Petition #89-1	
LEE PROPERTY REZONING	
PAW CREEK TOWNSHIP - MECKLENBURG COUNTY	
scale: 1" = 30' date: 6/16/88 project: 8812	Proposed Zoning and Site Plan Amendment
TURNBULL DESIGN GROUP, P.A. 1815 PARK DRIVE, SUITE 206 CHARLOTTE, NORTH CAROLINA 28204 (704)375-8154	R-1

CHARLOTTE-MECKLENBURG PLANNING COMMISSION INTER-OFFICE COMMUNICATION

SUBJECT: Administrative Approval for Petition #89-1 by Roger R. Lee Tax Parcel #031-047-01, 05, 03 P.O.

SUBJECT: Administrative Approval for Petition No. 89-1 by Roger Lee,
Tax Parcel No. 011-047-01, 05, 03 P.O.

**Petition #88-62-87-1**  
**LEE PROPERTY REZONING**  
 PAW CREEK TOWNSHIP - MECKLENBURG COUNTY

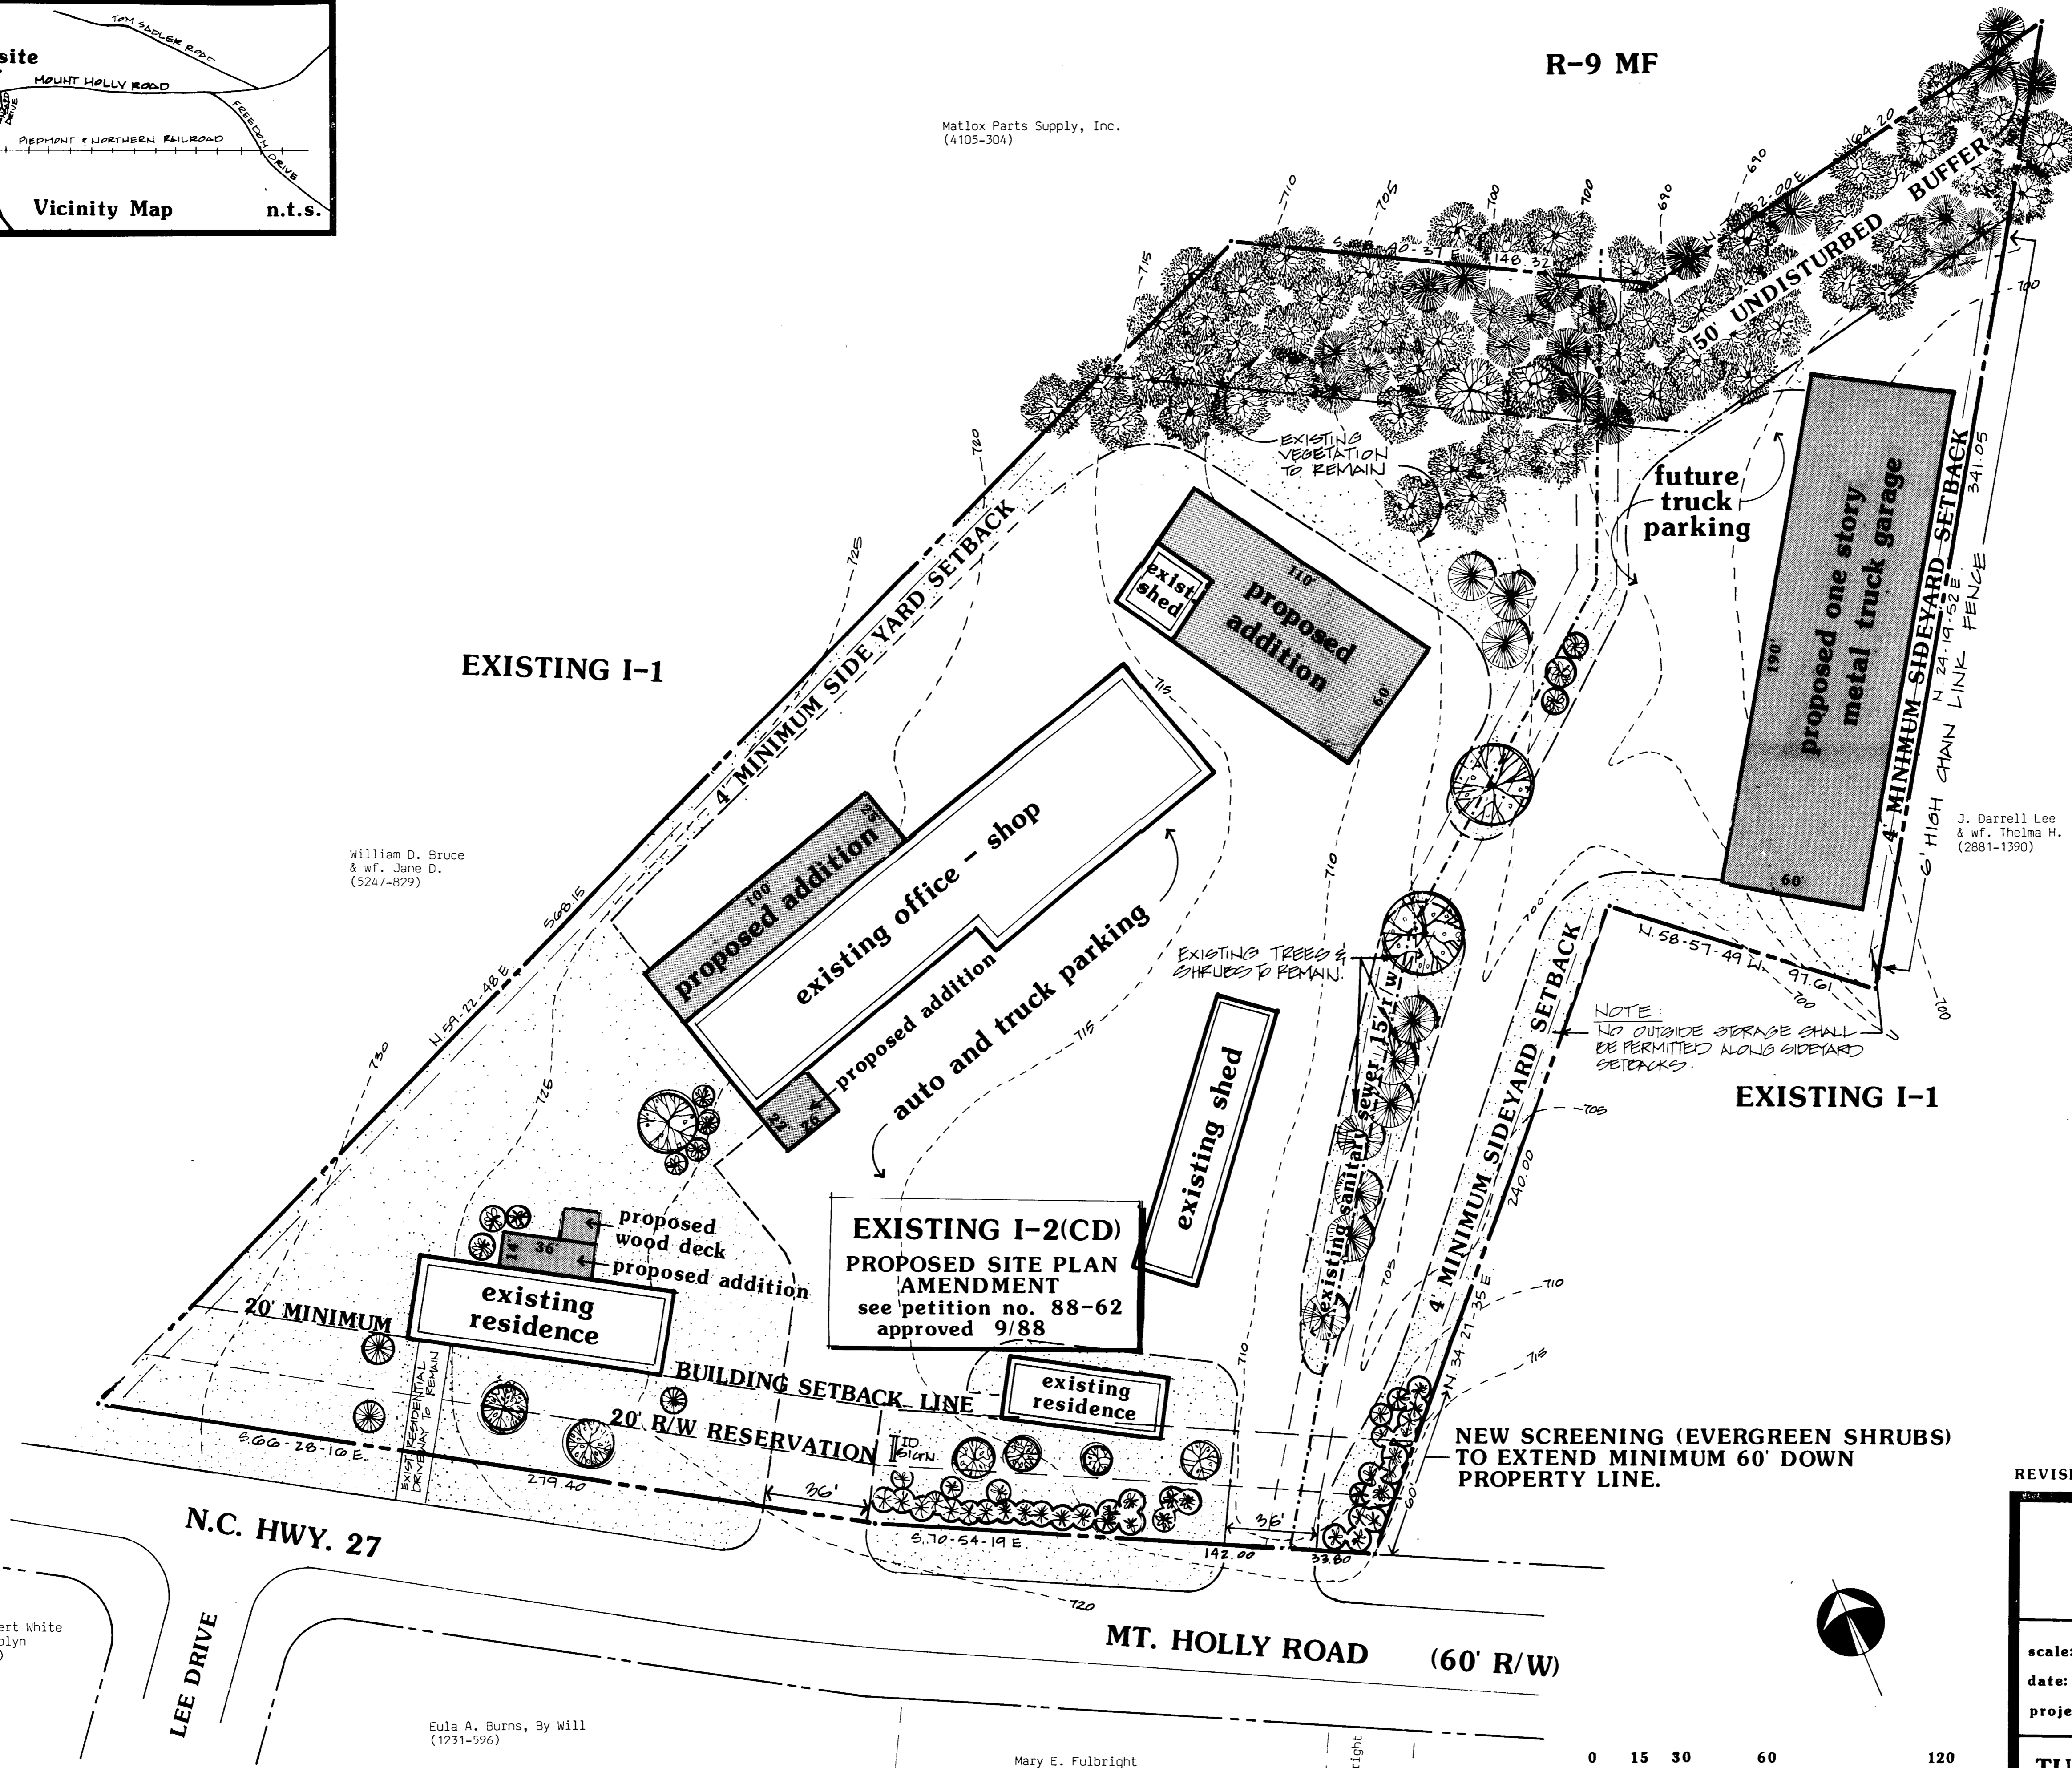
Attached is a revised plan for the above mentioned rezoning petition. The plan has been revised to show new building sizes and configurations. The total square footage for the site has remained the same. Since this change is minor and does not intensify the site I am administratively approving this plan. Please use it when evaluating requests for building permits.

June 18, 1990
 ATTENTION: CHARLOTTE-MECKLENBURG PLANNING COMMISSION
 I am requesting administrative approval for a change on our approved site plan #89-1 for Roger R. Lee.
 When I applied for the site plan approval, I was planning to add on to an existing shed, that was separate from the main shop. When Hurricane HUGO came through, this existing shed was damaged severely. It would not be feasible to repair it. I would prefer to remove it and add the proposed addition to the end of the main shop. This would be a much more economical way to enlarge and would make a much nicer finished project.
 I realize that one of your main concerns is the destruction of existing trees and vegetation. This proposed change will not in any way destroy any trees or vegetation. The area to be used is now being used as an equipment yard for parking and the area of the existing shed. The proposed building will not go into the 50' buffer zone.

The first change is the size of the building. We need to make the building that is noted on the site plan as the proposed one story metal truck garage, a little larger. We now want to build a building that is 42' x 150'. On the original plan it called for a building that measured 42' x 120'. The cost of building this extra 1,260 sq. ft. was very nominal because a building that is 150' long is more standard with the pre-fabricated metal builders.

My second change is that I need to move the building closer to the front property line. I need to do this so I can locate both of my future buildings within the required distance of a public fire hydrant, which I am going to have to have installed. If I leave the building where it is on the site plan, I will have to put in a private fire hydrant, which cost THREE (3) times as much. My building would still have the proper amount of set-back and we are only talking about moving it a few feet, but this small amount would help me out a lot.

Attached is a revised plan for the above mentioned rezoning petition. The plan has been revised to show a minor modification to the size and location of a building along the eastern property line. The total proposed building area is still below the 20,800 approved by the City Council and the new location for the building still meets all minimum yard requirements.
